Pipers Flat Rail Unloader Modification 1 (06_0271)

OEH Review

Pipers Flat Unloader modification 1

Figure 7.17 Location of sites and PADs recorded during the survey.
(Map supplied by SKM)

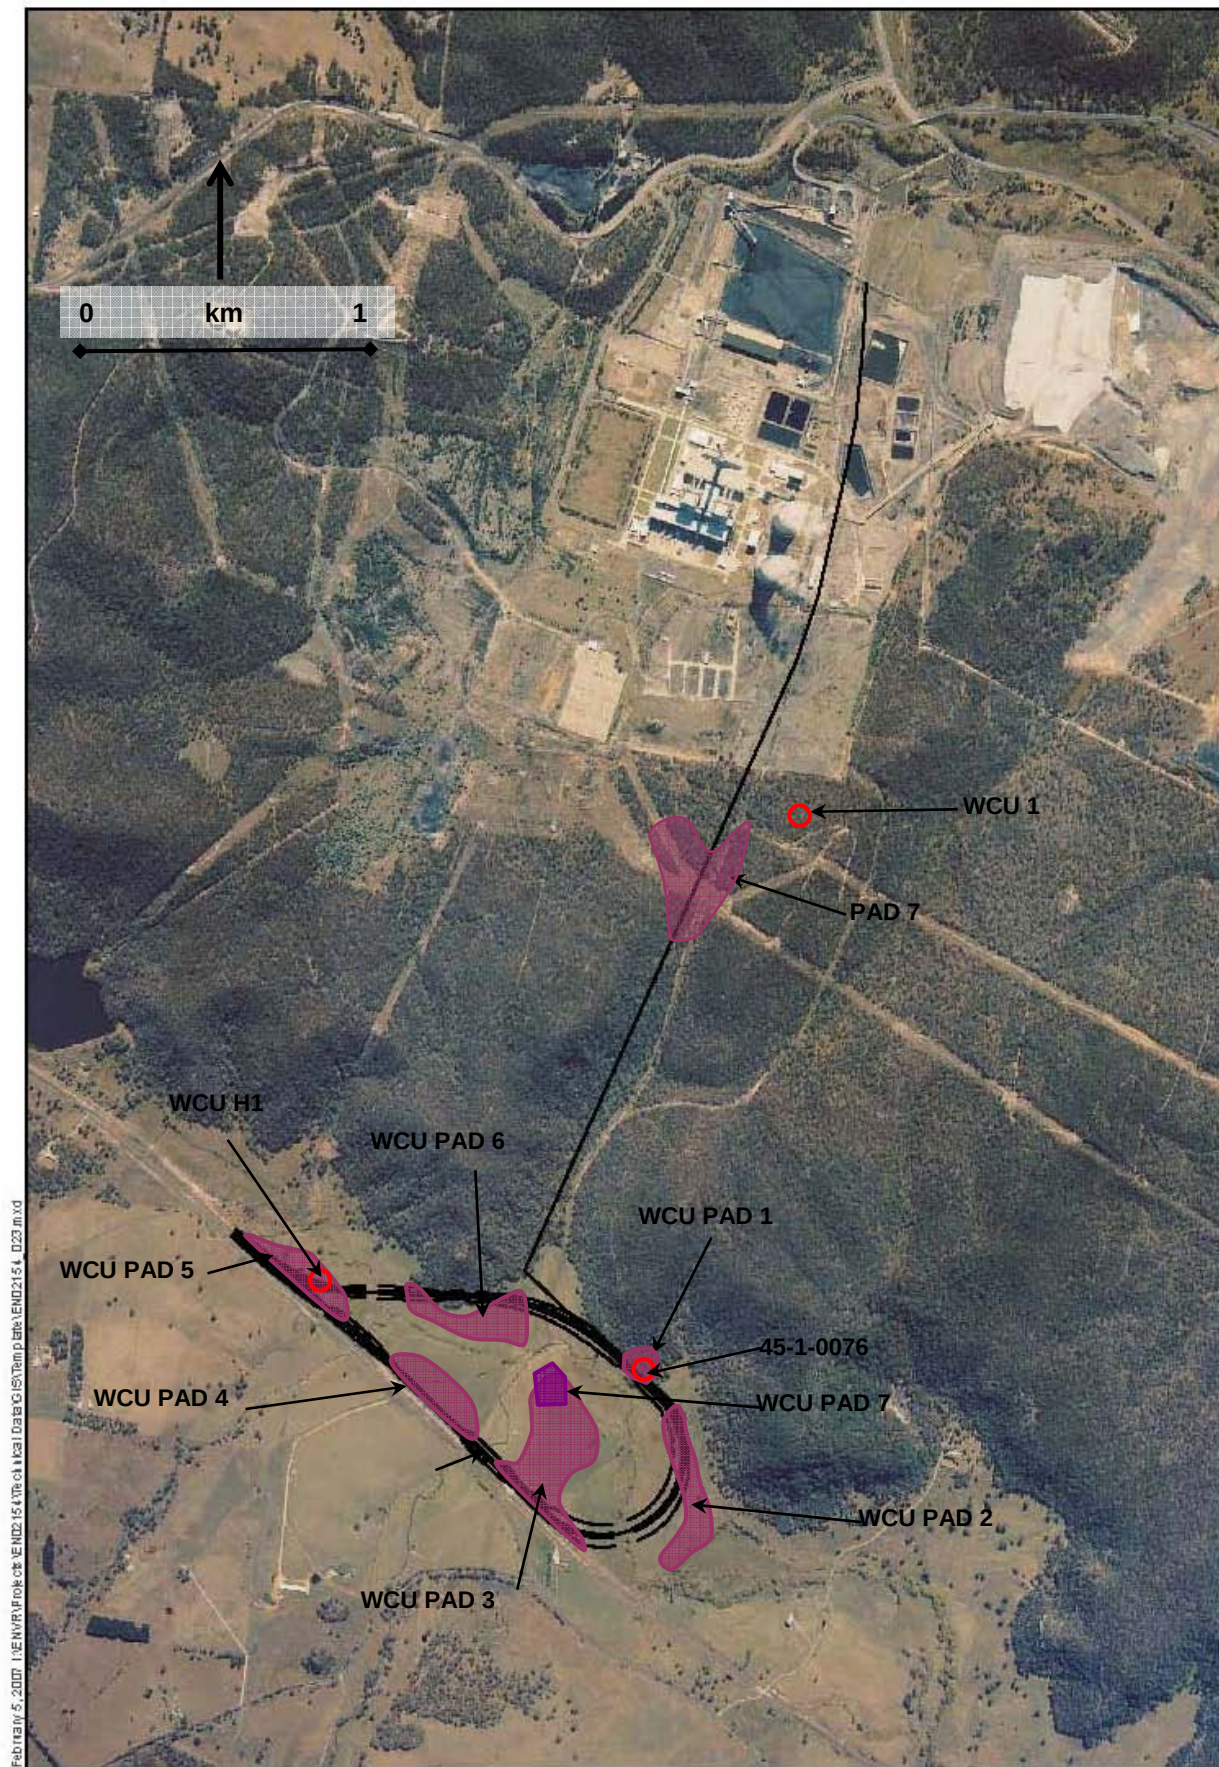
The report descriptions of registered AHIMS sites in the local area also show limited scientific research potential. The ACH assessment report concludes that several PADs that intersect the development footprint (PADS 3 to 6) have potential for moderate to high importance. OEH is unable make a judgement of this finding based on the information presented in the report but accept, in principle, the report's recommendation for further investigation of the PADs by means of test excavation to determine if artefacts exist below the surface and to salvage any prior to construction of the rail loop.

OEH see merit in revaluating the sensitivity potential of PADS 3 to 6 because of current drought conditions and to use the visit to re-engage with the Aboriginal community including, other interested parties that may have cultural knowledge of the project area. The visit would also be an opportunity determine the scope and scale of any proposed test excavation works relevant to the proposed development footprint.

4.1 Undertake a re-evaluation of Potential Archaeological Deposits (PADs) 3,4,5,6.

Figure 2 | Approved (black) and Proposed (pink and red) Rail Loop and Conveyor

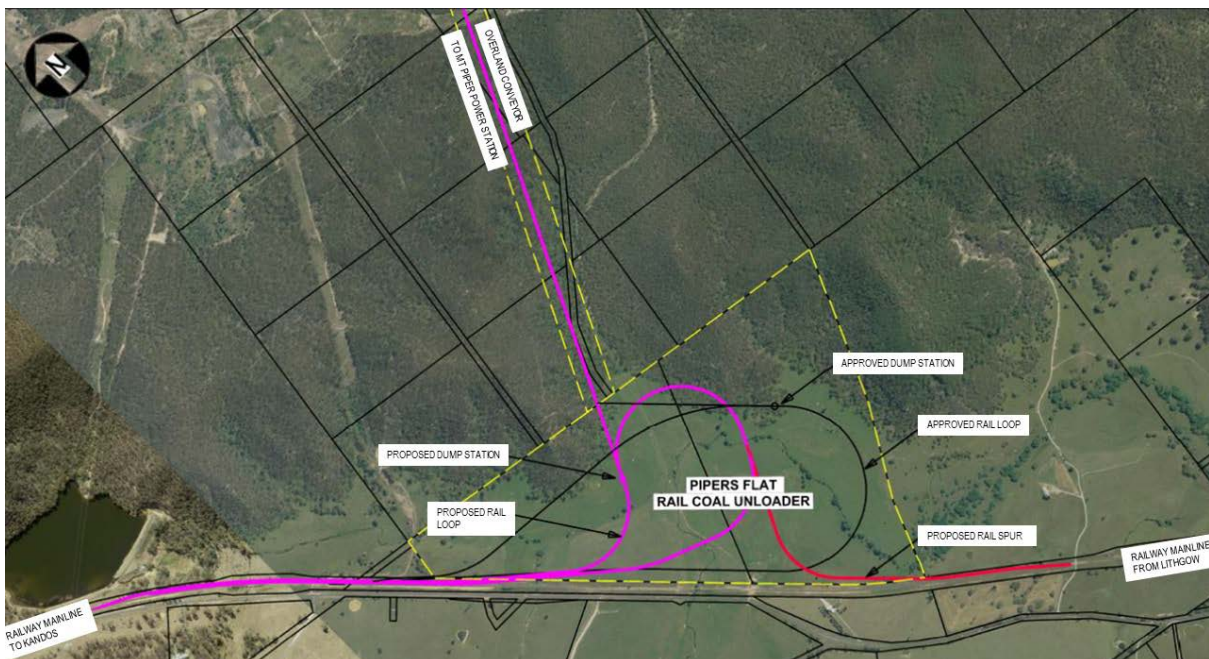
OEH has been unable to ascertain how the quantum of native vegetation to be cleared for the modification differs from the amount covered in the original consent for the project (06_0271), although a letter to OEH from Lycopodium on 22 April 2018 indicates that the rail loop component is likely to disturb an area equal to or less than the approved design.

There is no quantification in either the original environmental assessment (SKM 2007), or in the ecological report for the modification (AEP 2018), of how much native vegetation, and which communities, will be cleared for the rail loop and conveyor belt. The area (hectares) of each plant community type (PCTs) to be cleared is required to enable an appropriate compensatory package to be developed for the entire project.

- 1.1 The area (hectares) of each PCT to be cleared for the entire project (ie rail loop, conveyor and associated infrastructure) be quantified prior to construction commencing, and an appropriate compensatory habitat package developed consistent with condition 2.38 of consent 06_0271.
- 1.2 A completion date for the compensatory habitat package is included in the modified conditions of consent.
